23/07/2020

Shoalhaven Starches Expansion Project MOD 17 (06\_0228-MOD 17)  
**Request for Additional Information**

## Attachment 1

Figure 7 – Specialty Products Building Layout (with MOD 17 changes)

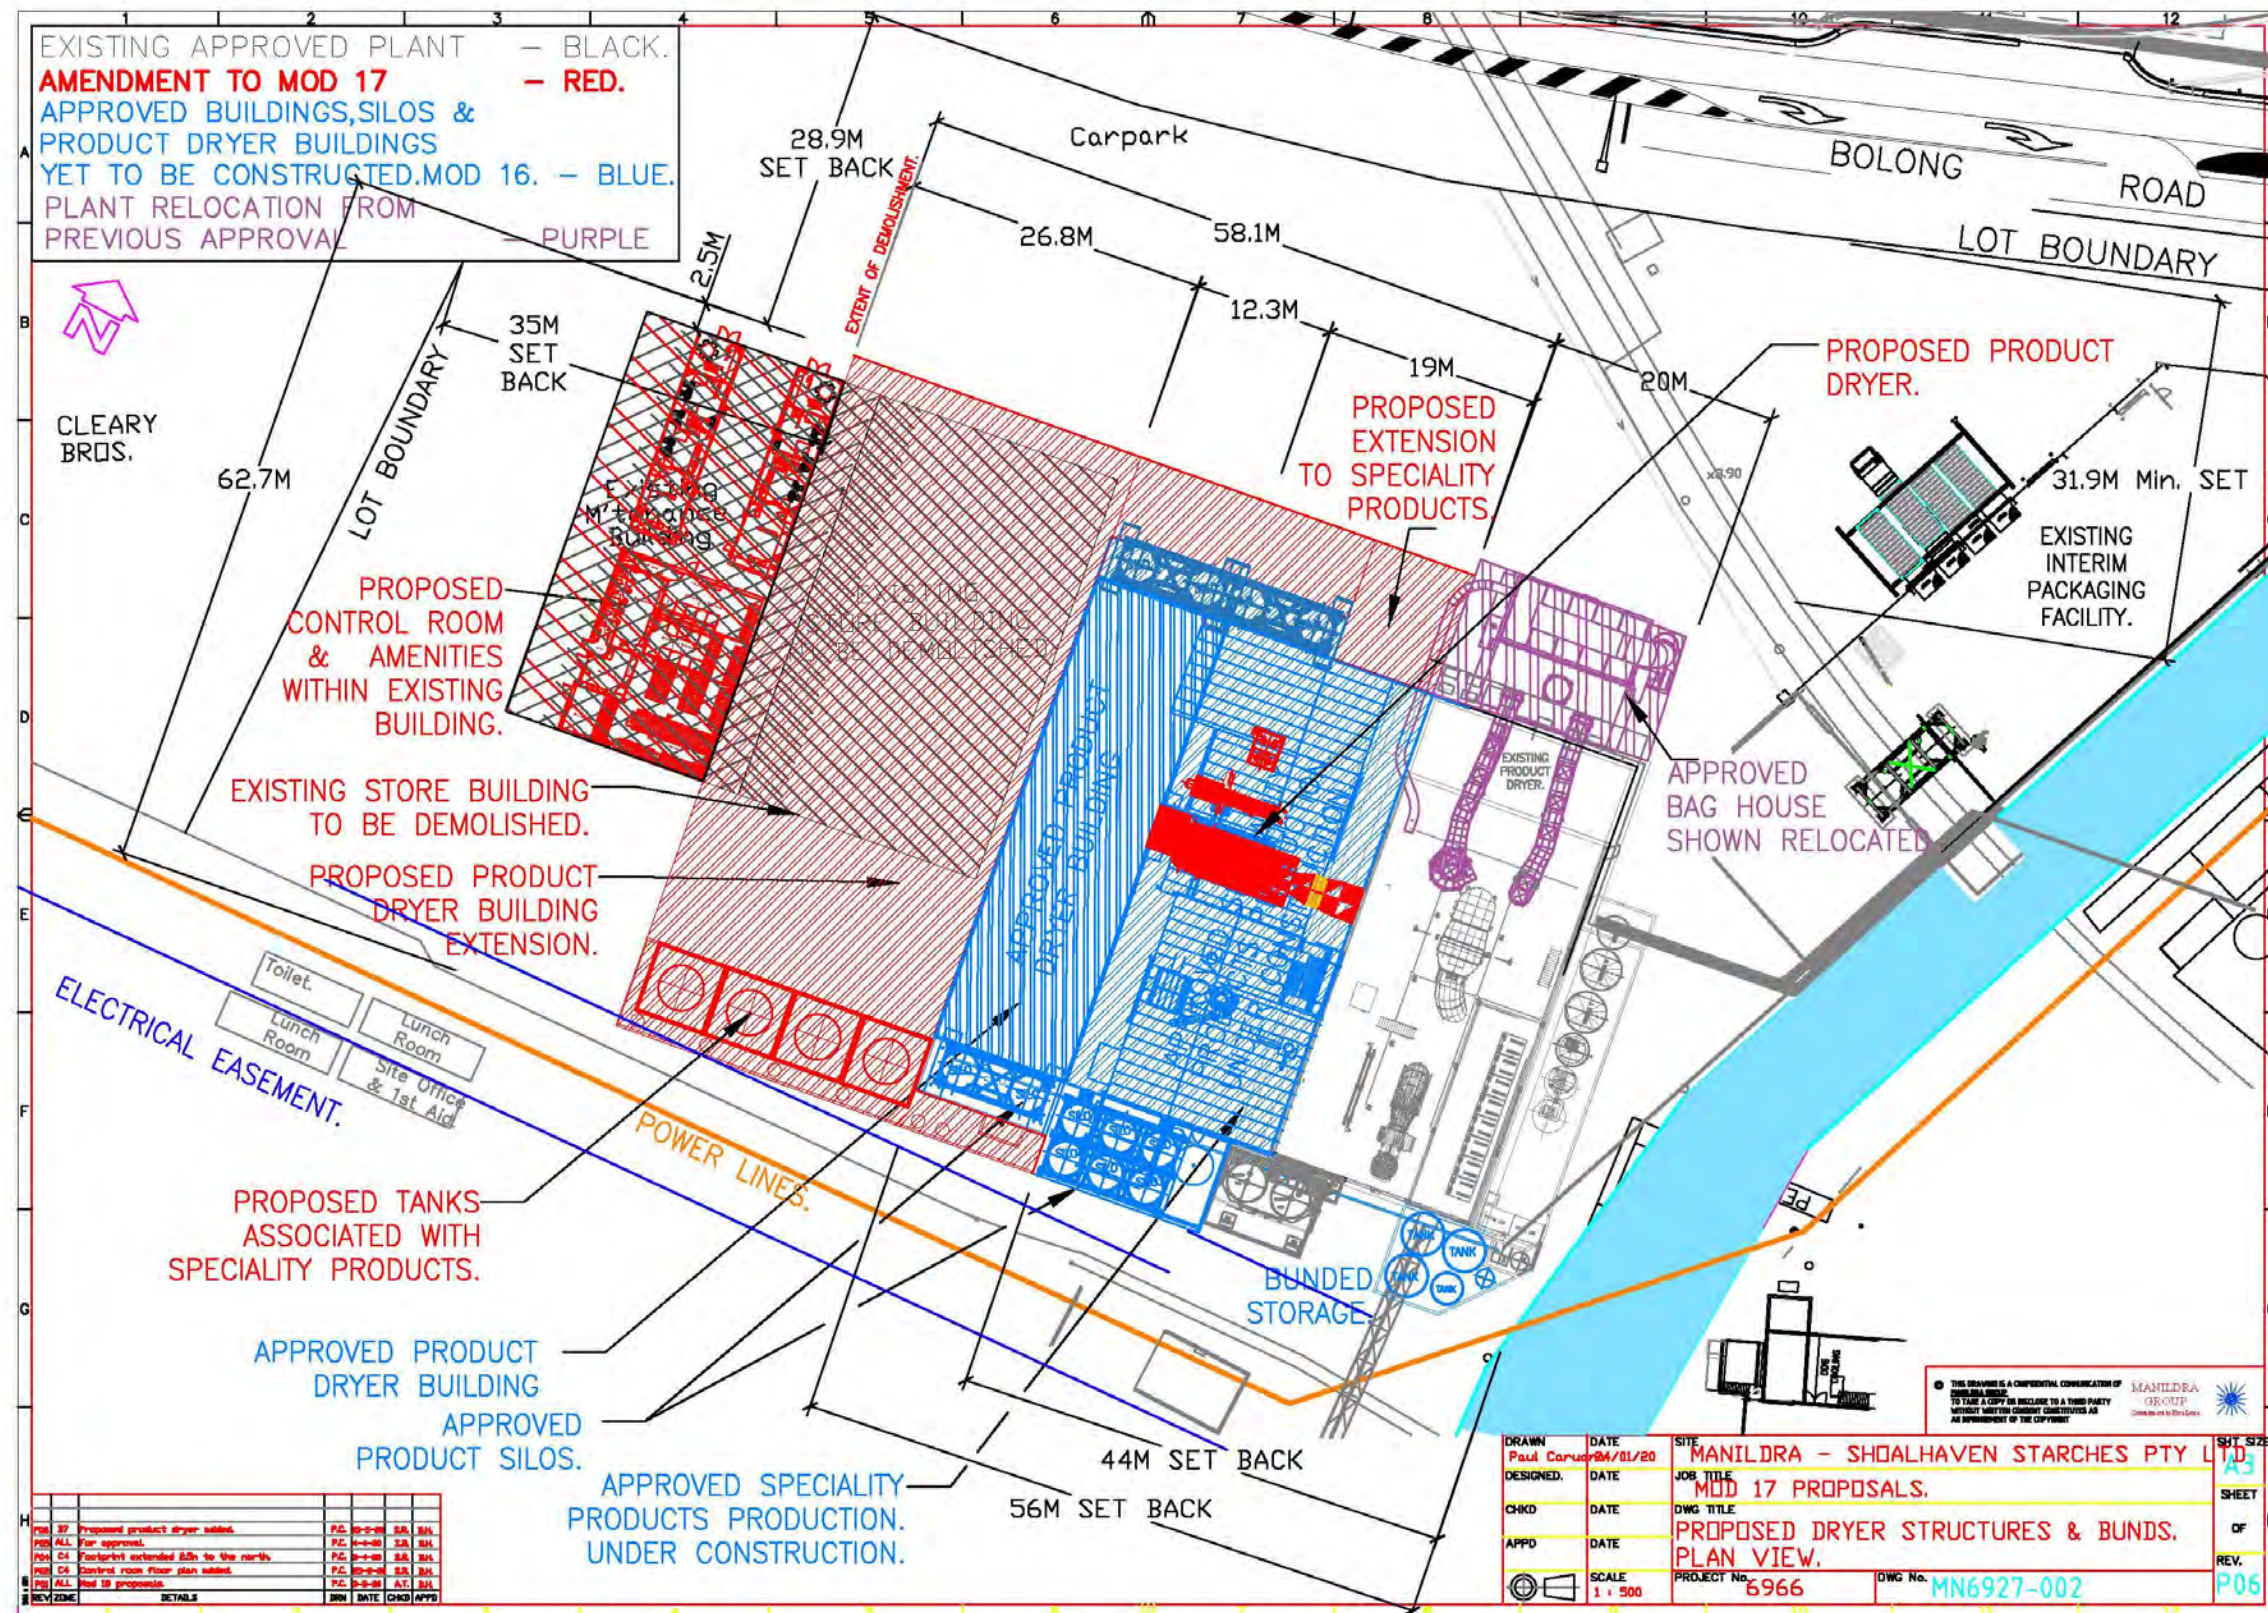
- It is noted that the Preliminary Hazard Analysis (PHA) report (dated 18 June 2020) prepared by Pinnacle Risk Management Pty Ltd has been revised to assess the changes proposed in Modification 17. The Department notes the PHA details “the chemical storage tanks (caustic soda, hydrochloric acid and cationic reagent) are to be relocated to the south of the GD8 building” however, the addendum Statement of Environmental Effects (SEE) prepared by Cowman Stoddart Pty Ltd (dated 19 June 2020) describes additional bulk chemical storage to the south of the PDB and SPB buildings.

- Whilst the PHA concluded that the modifications presented no significant increase in the risk profile of the site, it is unclear if consideration was given to risks associated with the provisions for future bulk chemical storage noted in *Section 2.3 Additional Bulk Chemical Storage* of the Addendum.

- It is recommended that clarification be provided as to whether the Modifications are proposing additional bulk chemical storage, or relocation of the existing; caustic soda, hydrochloric acid, and cationic reagent storage.

- If the bulk chemical storage tanks are not to be relocated, please provide the details of the additional chemical storage tanks including the chemicals to be stored within these tanks, the tank capacity and the proposed location. In addition, please provide comment on the associated safeguards and risks if these are additional bulk storage tanks
